## PLANNING CONSULTATION RESPONSE

<b>Application No</b>	2025/1032
<b>Proposal</b>	Single storey side extension and dropped kerb
<b>Address</b>	102 Manchester Road, Thurlstone, Sheffield, S36 9QW
<b>Date of Consultation Reply</b>	25/03/26
<b>Consultee</b>	Highways DC

PROPOSED PLANS & ELEVATIONS

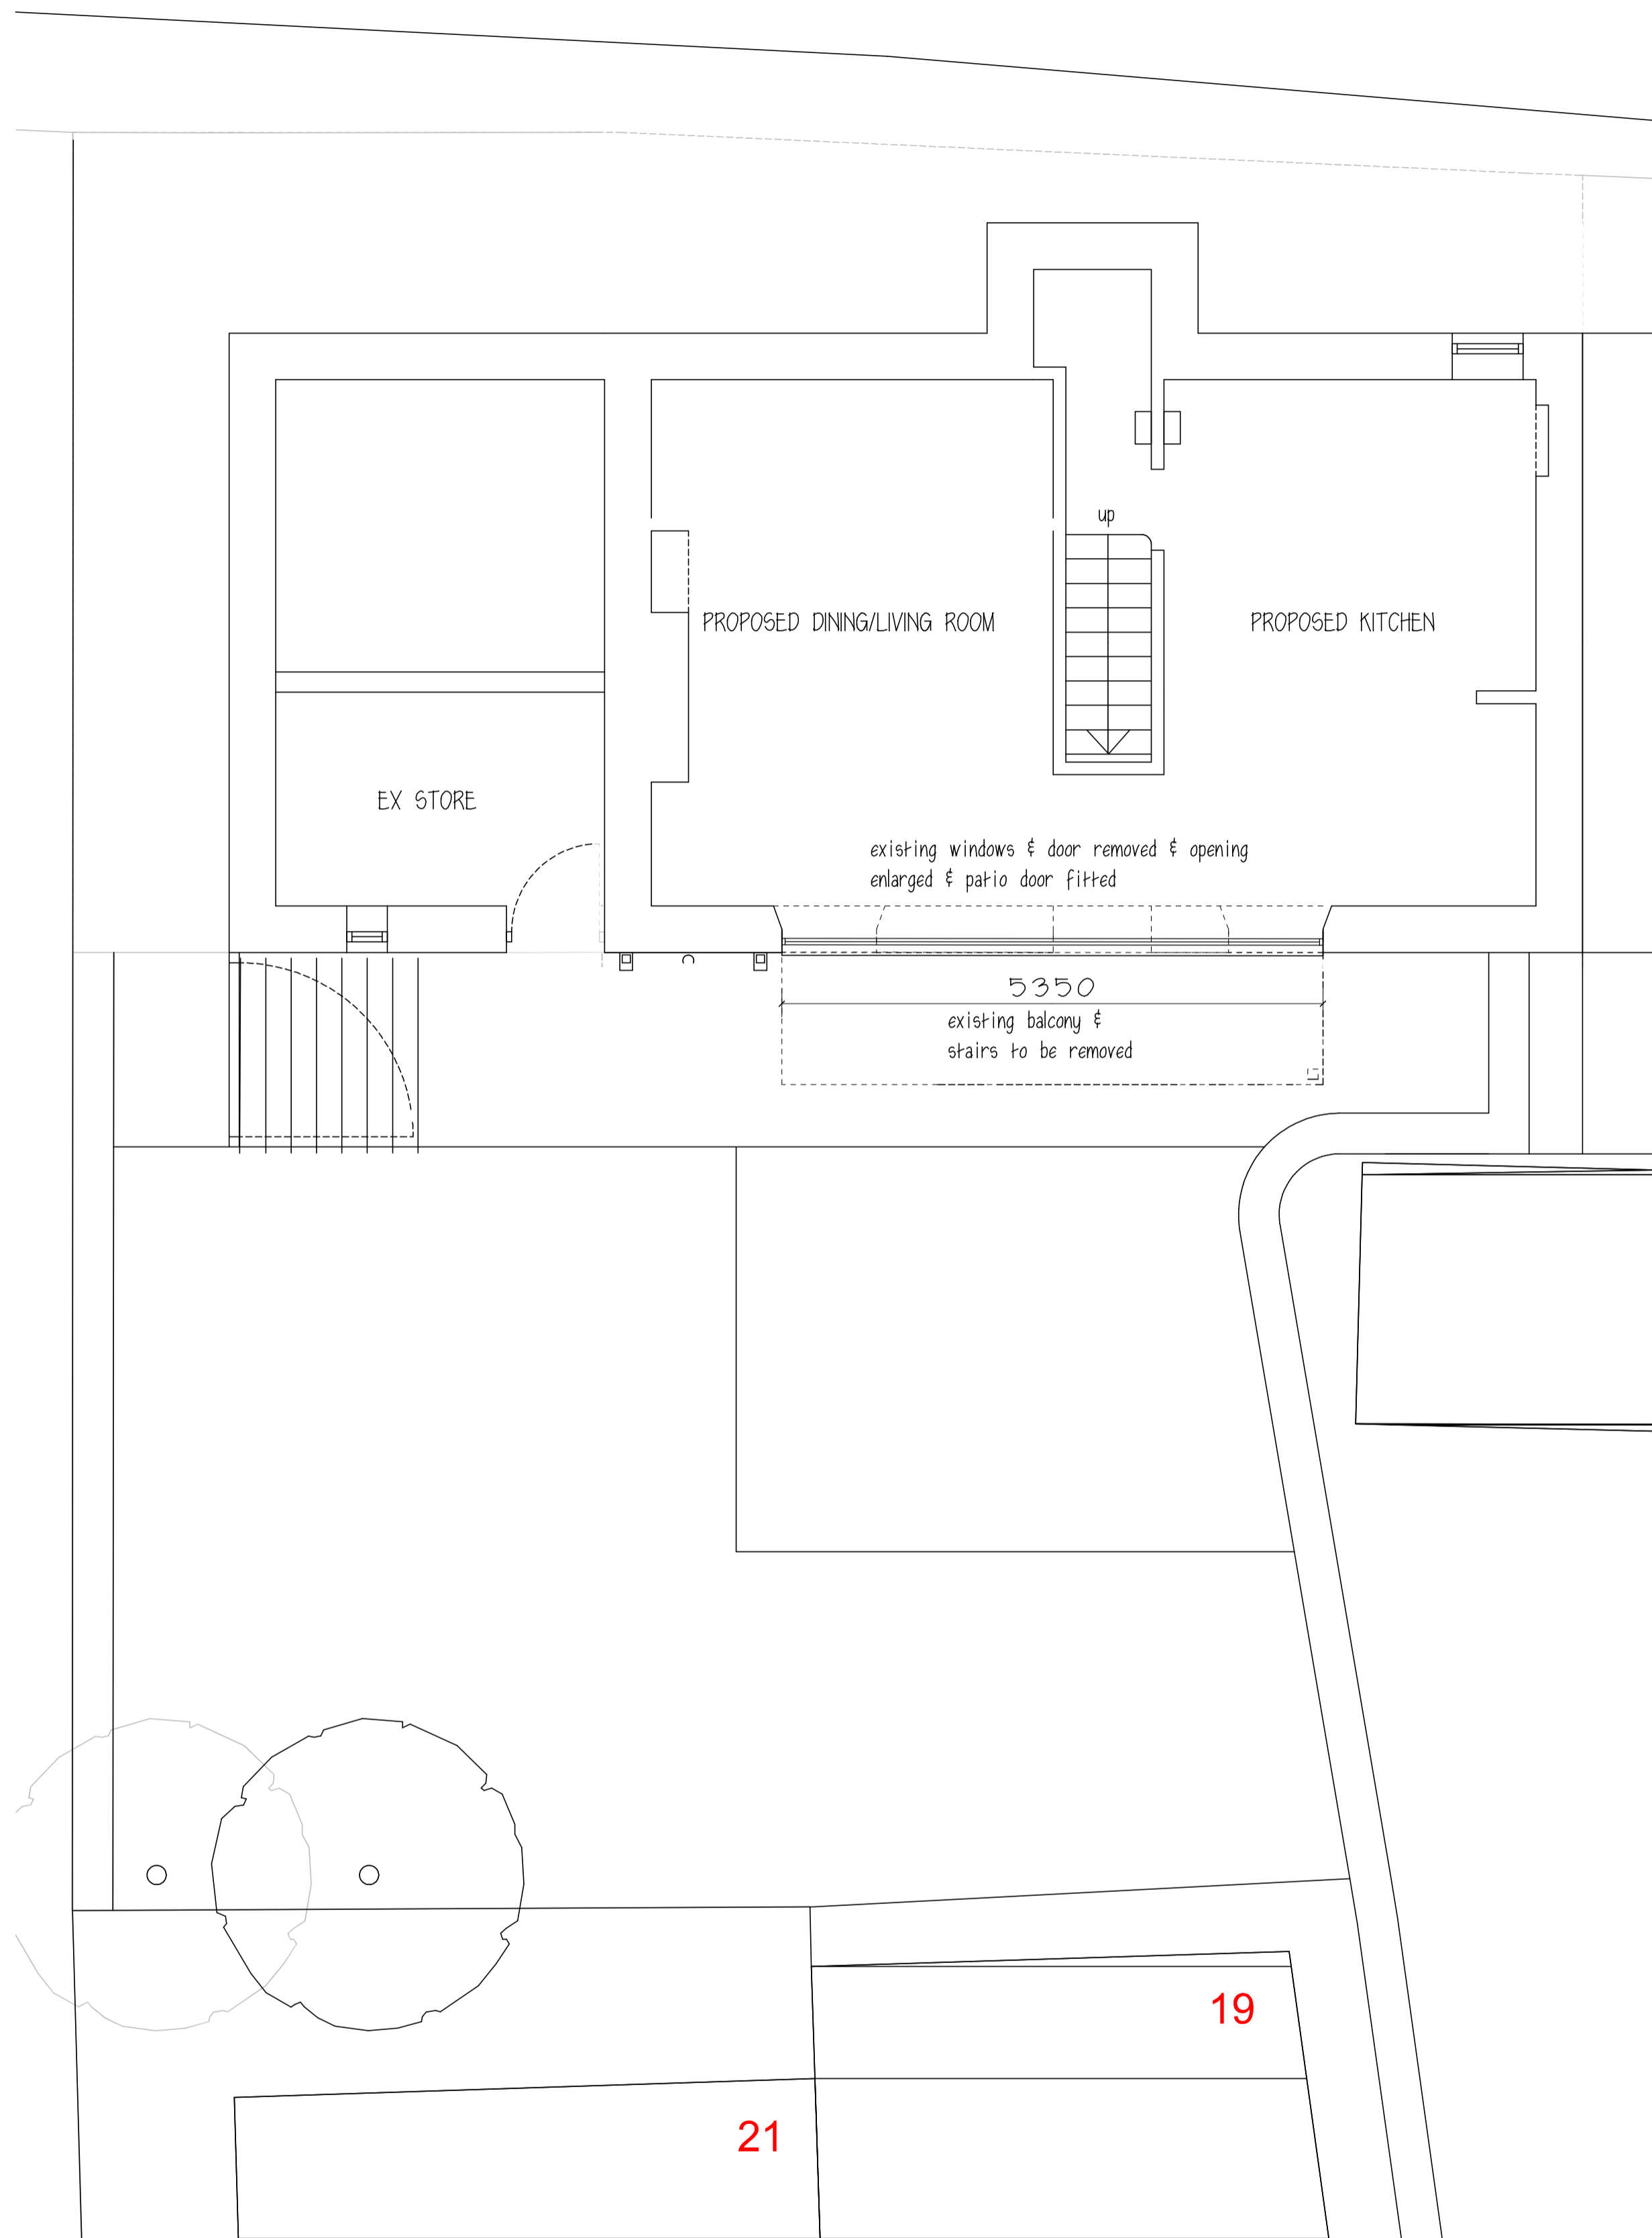
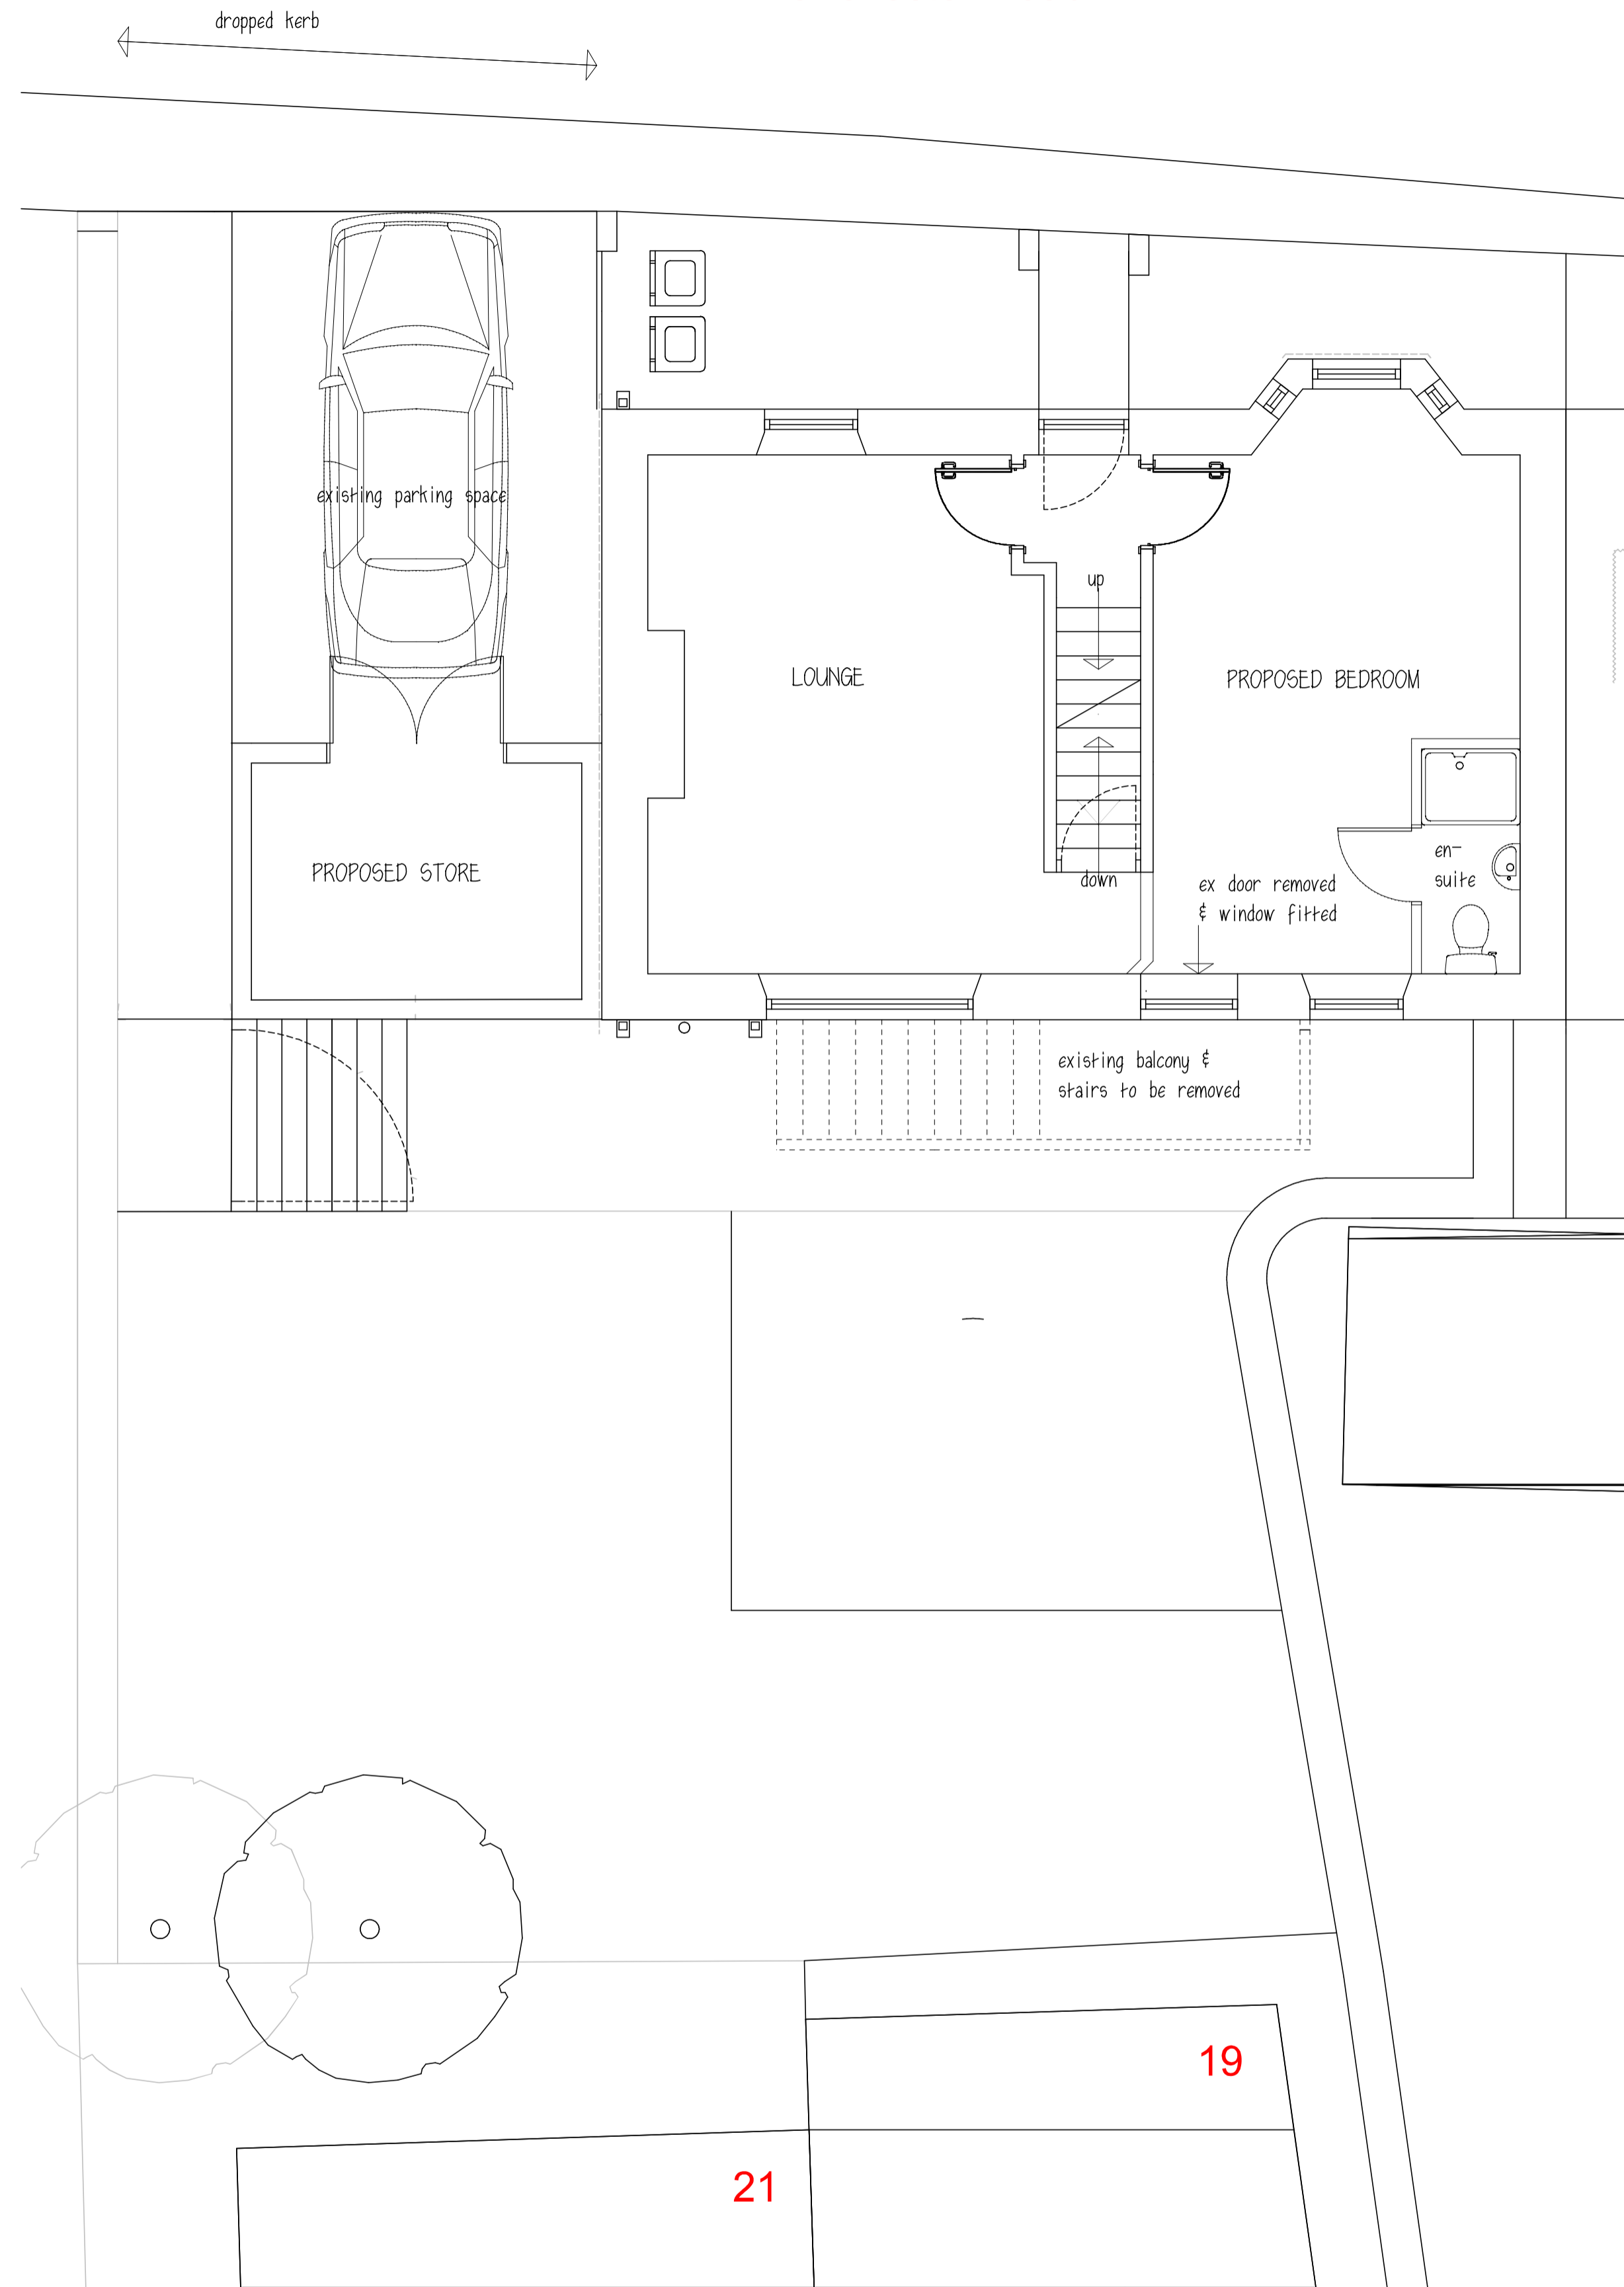
The proposal would create a permanent storage space adjacent to the dwelling and also formalise an off-street parking space by installing a dropped kerb to allow access off Manchester Road.

Highways DC officers would expect internal turning to be provided off a classified road to allow vehicles to enter and exit the highway in a forward gear. It was noted in 2023 that “On both the easterly and westerly approaches to the site, visibility is obscured due to on street parking and alignment of the carriageway. In some situations, the access would be completely concealed from view. Due to the prevalence of on-street parking in the area, it is necessary for cars travelling east along Manchester Road to encroach into the opposing carriageway lane to pass parked vehicles for considerable lengths and those travelling in a westerly direction to be aware of this and potentially give way to oncoming traffic. There is also a bus stop opposite and to west slightly of the site. Furthermore, the footway reduces in width significantly, directly adjacent to the property, which could result in pedestrians having to step out into the carriageway. All of these factors result in drivers having to be very aware of their already busy surroundings and the introduction of an obscured vehicular access that subsequently does not meet the required minimum standards, gives rise to serious road safety concerns”.

These concerns remain, and HDC officers would therefore not wish to see this hard-surfaced area formalised as a parking space for the above safety reasons and so as not to set a precedent of providing substandard off-street parking facilities on this busy, A-classified road. Objection is therefore raised on highway safety grounds.
